**Charbon MOD 2 - Rehabilitation (MP 08_0211 MOD-2) and Clarence Colliery
Modification 6 (DA 504-00 MOD6)**

Thank you for your correspondence via Major Project portal (ref: PAE-9769641) on 6 October 2020, requesting Transport for NSW (TfNSW) to review and comment on the above.

The Modification Report (version dated September 2020) in support of the subject proposals was reviewed and the following comments are provided:

2.1.4 Main Western rail line

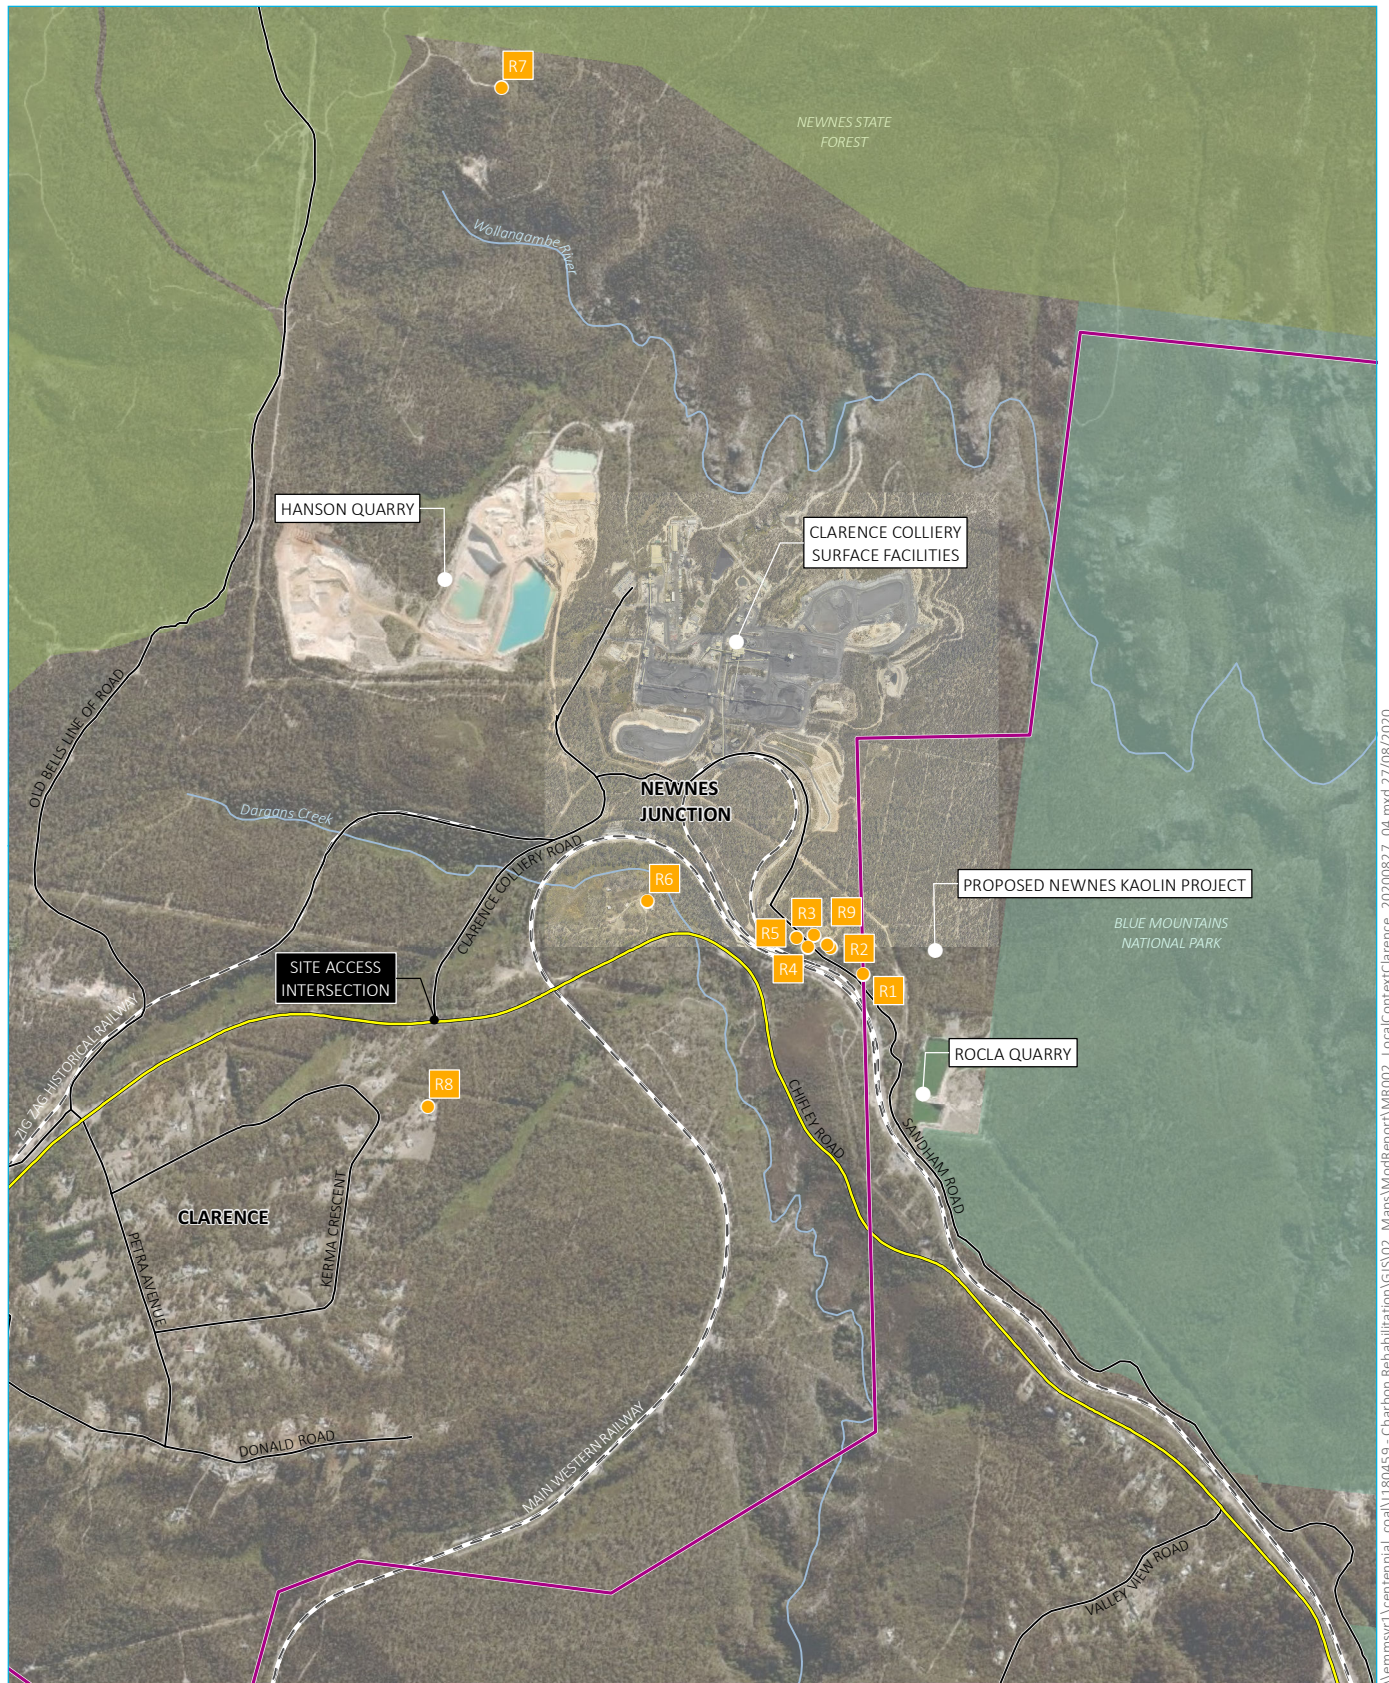
- It is not evident that consideration has been given to the impact of reversing train movements both entering and exiting the Clarence loop as both movements will result in blocking the Main Western Rail Line.
- Clarification is required on Section 2.1.4 and Table 8.9 of the Modification Report in regards to whether it has included passenger train movements to Broken Hill/Perth.
- The applicant is advised that the actual timing of the rail movements needs to be confirmed between an accredited rail operator and the respective network owners.

As part of its process of preparing the Response to Submissions, the proponent shall consult with Sydney Trains and JHR to address any impacts on the rail network in question.
